Transport
Roads & Maritime
Services

21 December 2012

**MP 09_0177 – EXPANSION OF MCWILLIAM’S WINERY, LOTS 165, 166, 168 AND 171
DP751709, JACK MCWILLIAM ROAD, HANWOOD.**

Project: ENVIRONMENTAL IMPACT STUDY  
Title: PRELIMINARY PROPOSED DEVELOPMENT IRRIGATION WATER PIPELINE

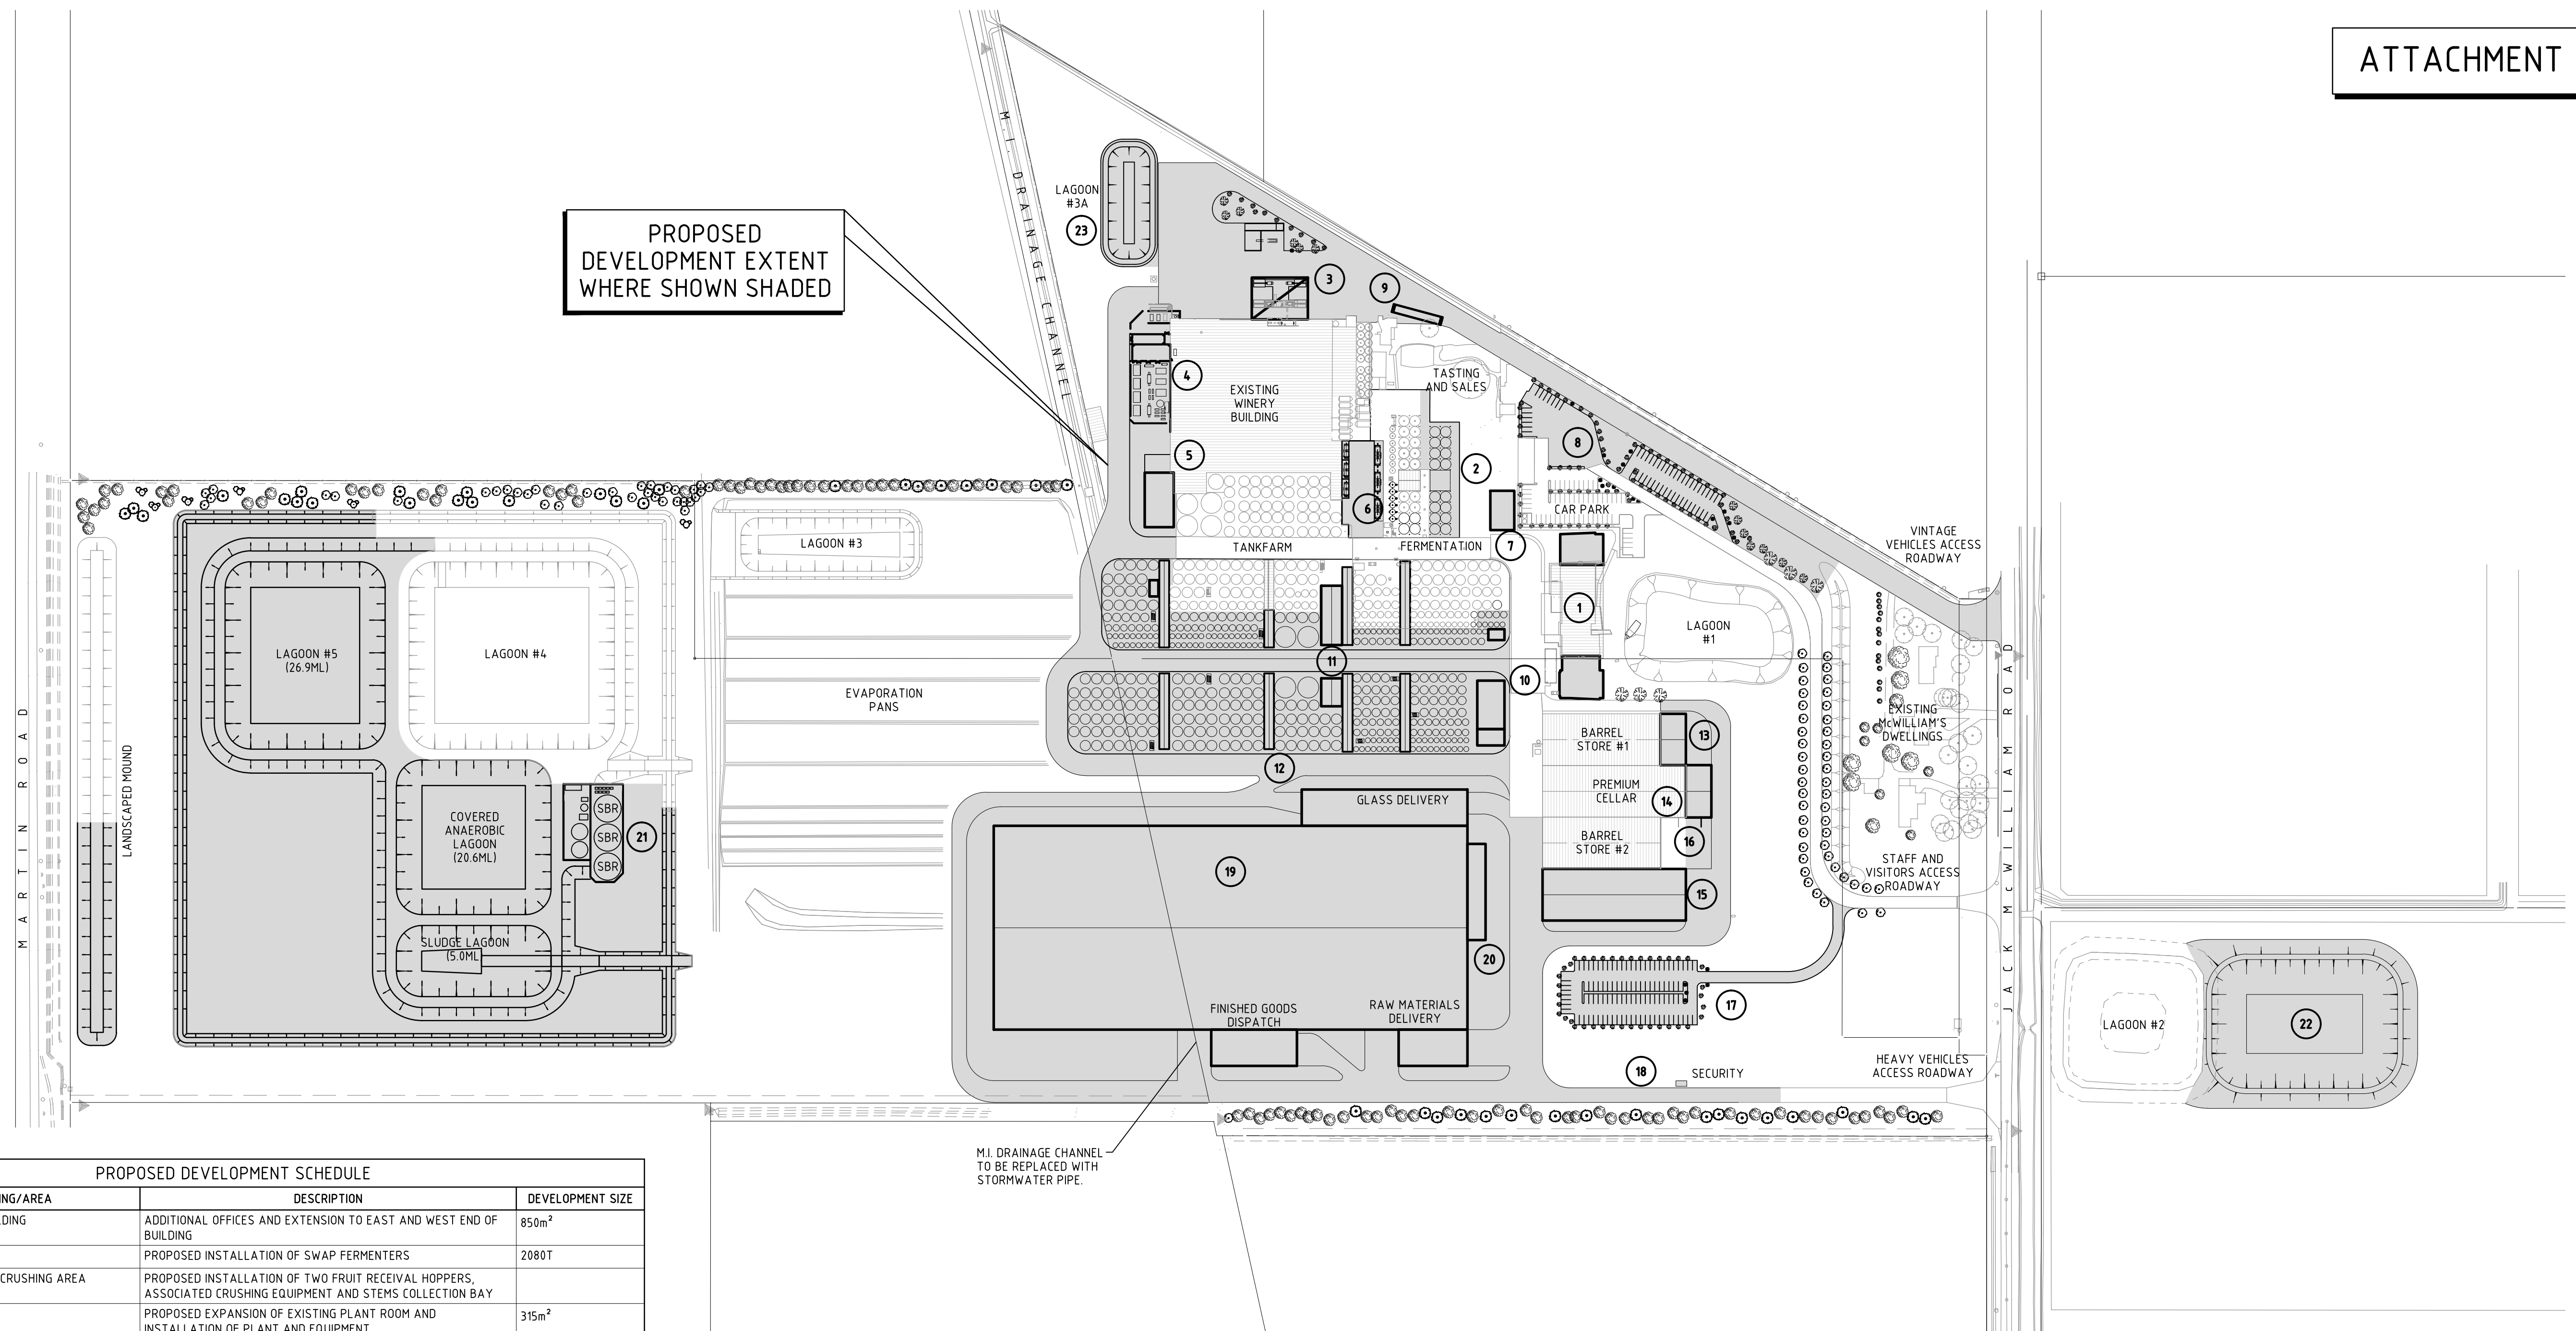
The proposal also includes the construction of a water treatment facility and ponds to be located on the western side of the Kidman Way. As this treatment facility is to be located on the opposite side of the Kidman Way to the processing facility it is anticipated that this will require the installation of pipes within the road reserve of the Kidman Way in order to pipe the waste water products from the processing facility to the treatment ponds. The submitted documentation provides little detail on the design of the intended pipe network and any proposed crossing of the road reserve of the Kidman Way

3. The proposed pipe network to be installed within the road reserve of the Kidman Way (MR321) shall be designed and constructed to the satisfaction of Roads and Maritime Services (RMS) and the Griffith City Council.
